WRITTEN REPRESENTATION ON BEHALF OF NORFOLK WILDLIFE TRUST

Application by East Pye Solar Limited for the East Pye Solar Development Consent Order

Planning Inspectorate Reference: EN0110014

Figure 8.3 - Non-Statutory Designated Sites within 2km
 Sheet 4 of 6
 Revision A

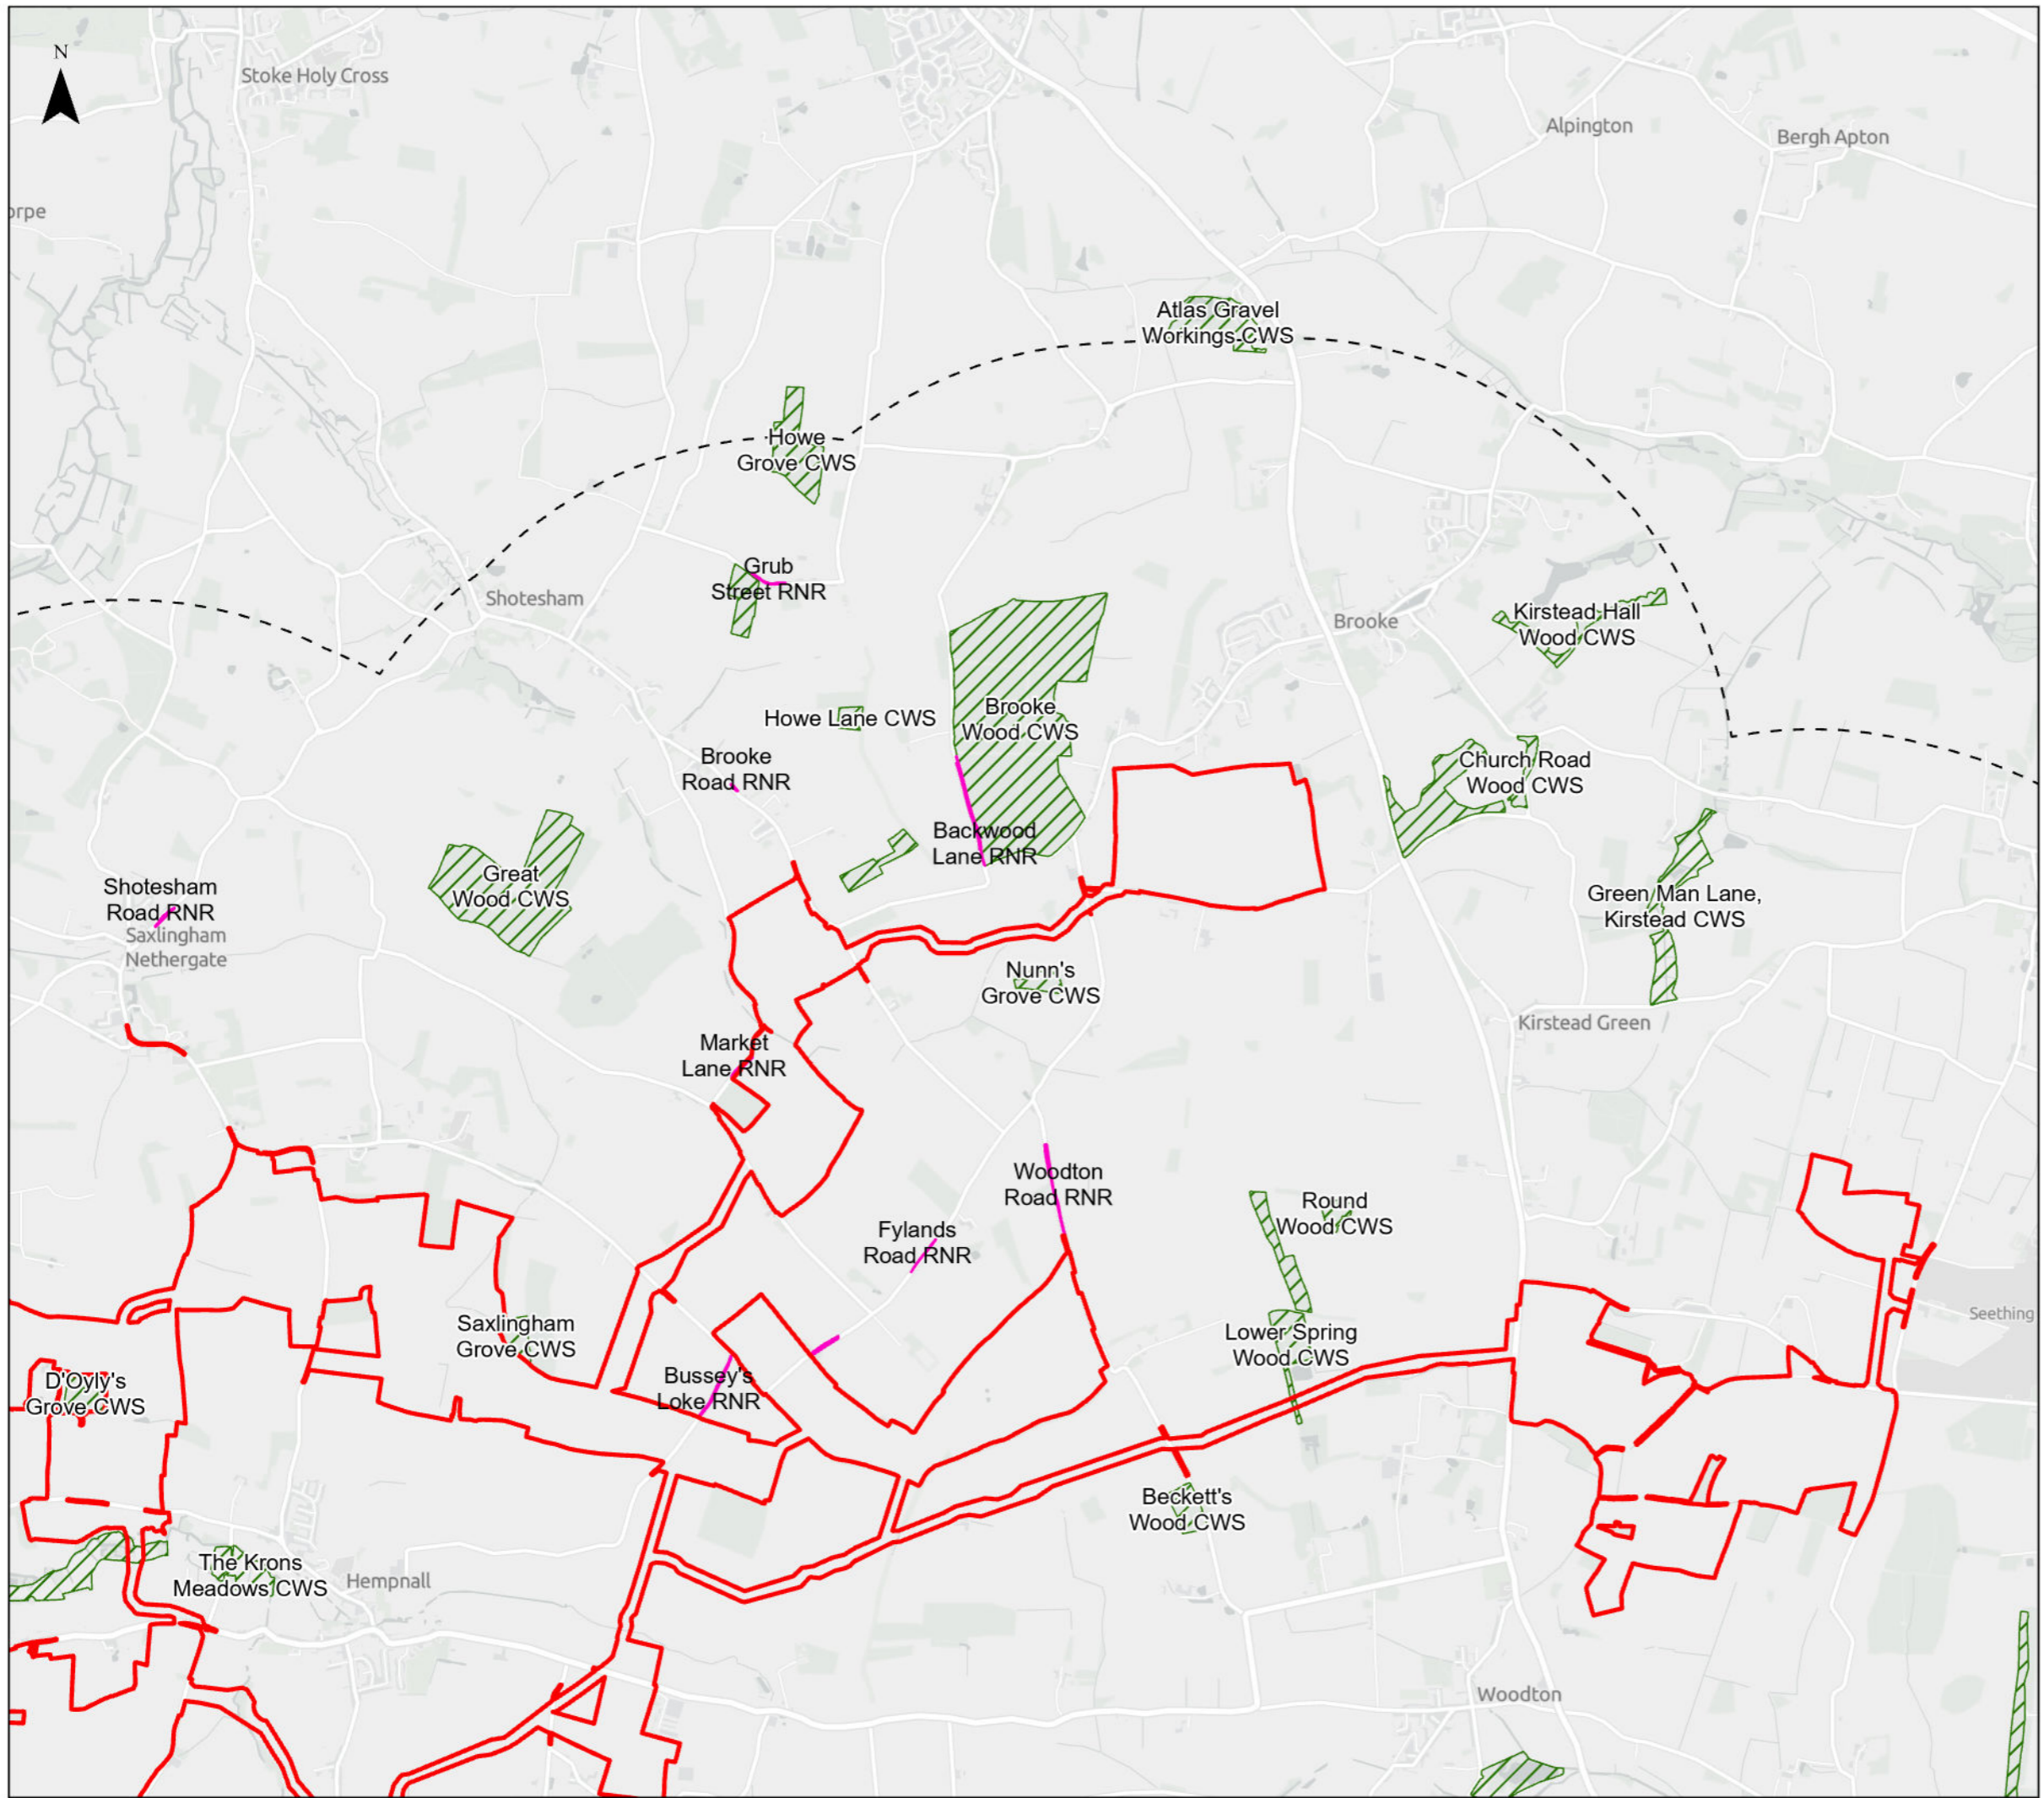
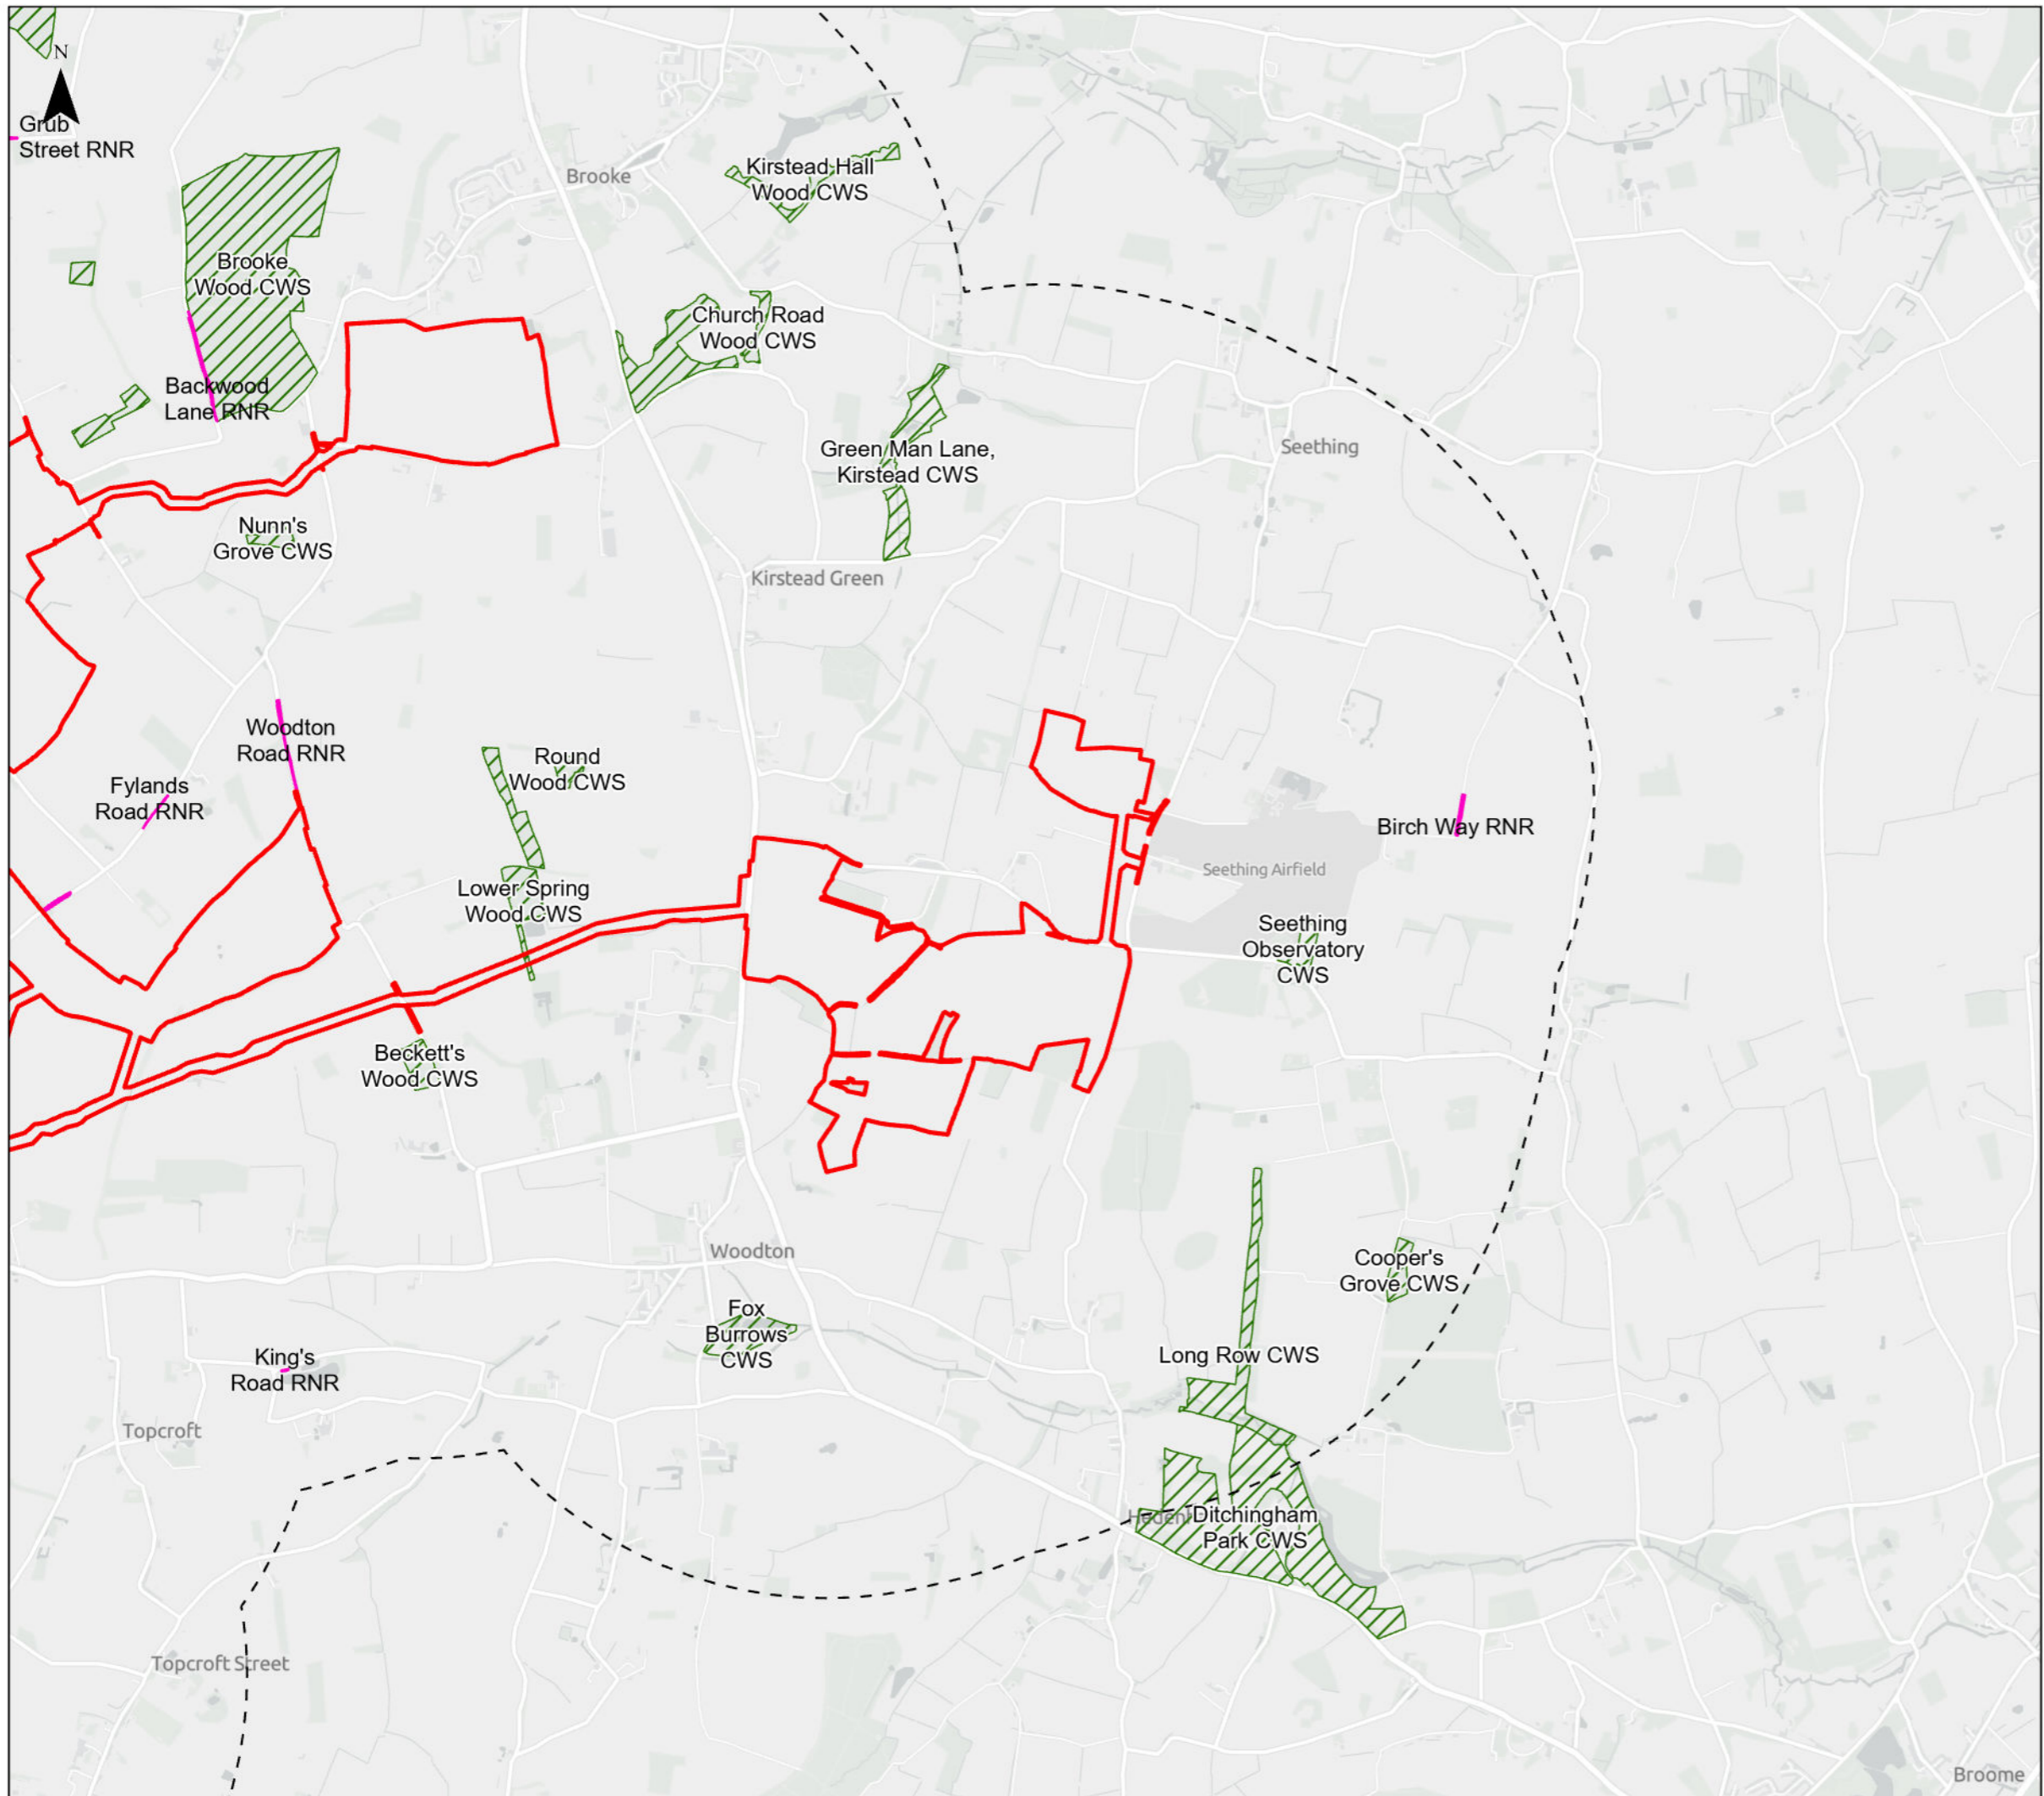
County Wildlife Sites represent an essential component of Norfolk's ecological network and often provide important habitat for priority species outside nationally designated sites. As outlined in paragraph 8.6.7 (ES Chap 8), the Order Limits include parts of two CWSs; Lower Spring Wood CWS (within CR9), and Fritton

Grange Meadows CWS (within CR7), and are adjacent/in the immediate vicinity of several others. The Order Limits also include or adjoin several Roadside Nature Reserves (RNRs), including Bussey's Loke RNR (Sub-Site 7G), Market Lane RNR (Sub-Site 8A), Parkers Lane RNR (Area 1) (CRC4), and Parkers Lane RNR (Area 2) (CRC4). Both direct and indirect impacts on wildlife sites and associated habitat networks must be avoided.
